Town & Country Planning (Control of Advertisement) (England) Regulations 2007 (as amended)

Application No: AB/59/21/A
Site Address: 61 High Street Arundel BN18 9AJ
Description of works: Installation of 1 x halo illuminated sign

Thank you for your internet representation made on 28th May 2021 which has been recorded as an objection with the comments as follows:

External Fascia Signage

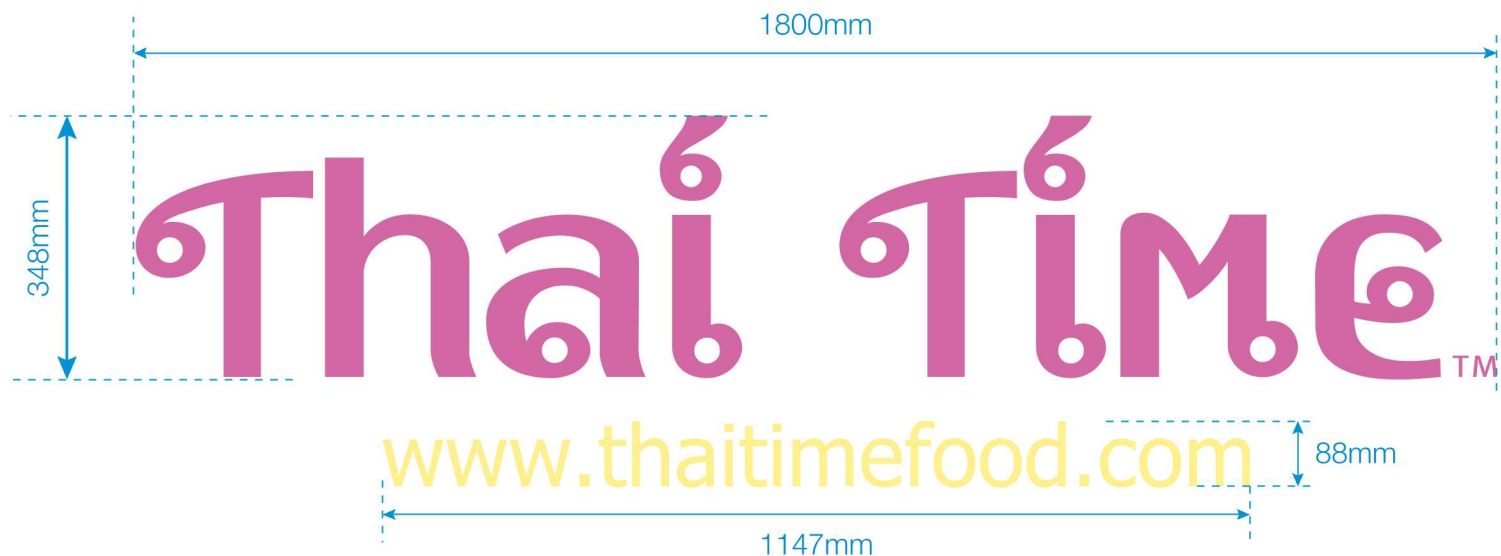
The Committee objected to the Application on the grounds that the illuminated sign is halo lit. The new wall mounted lighting should be in keeping with the character of the building.
